**An
Bord
Pleanála**

Board Direction

ABP-309513-21

The Board decided to grant permission generally in accordance with the Inspector's recommendation, for the following reasons and considerations, and subject to the following conditions.

Drawing file: Architecture / D1408-19-PL55 BLOCK N - Section and Elevations.pdf

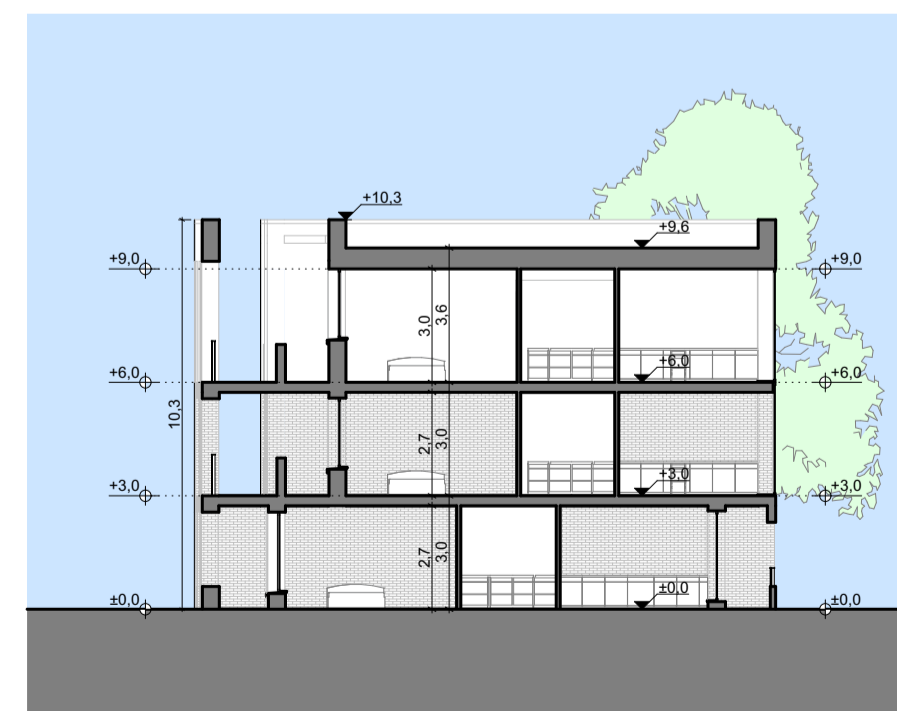
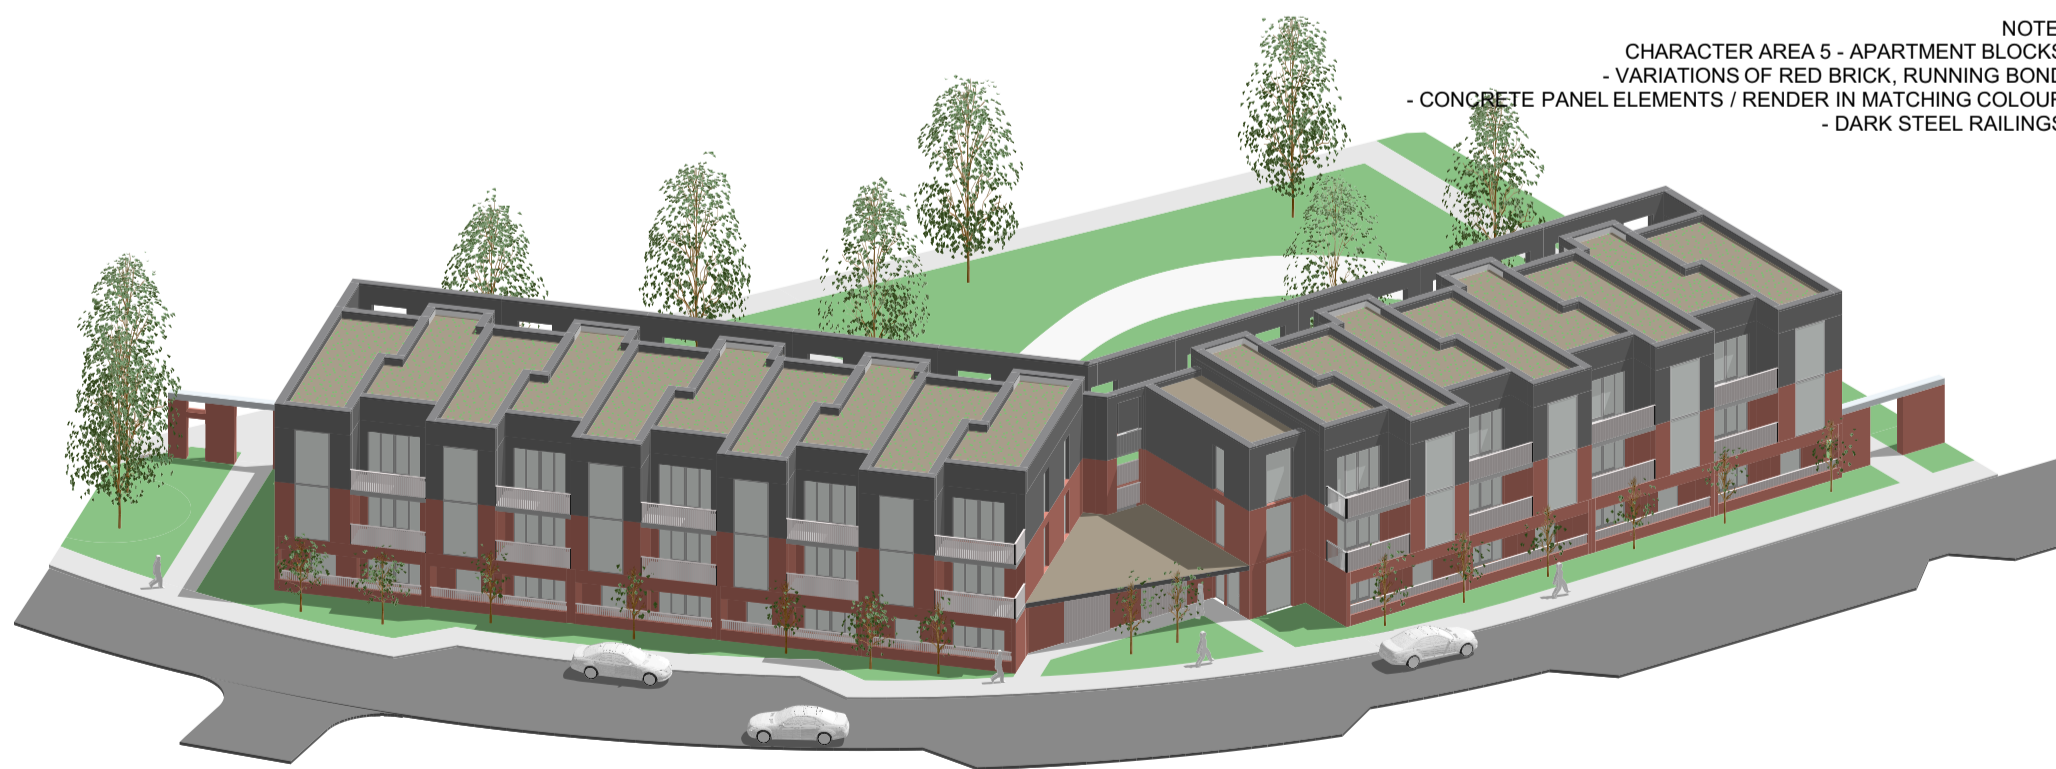
(b) The minor living room windows associated with unit numbers 429, 438 and 447 on the eastern elevation of Block N shall be fitted with obscured glazing, to avoid overlooking windows and balconies associated with Block M.

Revised drawings showing compliance with these requirements shall be submitted to, and agreed in writing with, the planning authority prior to commencement of development.
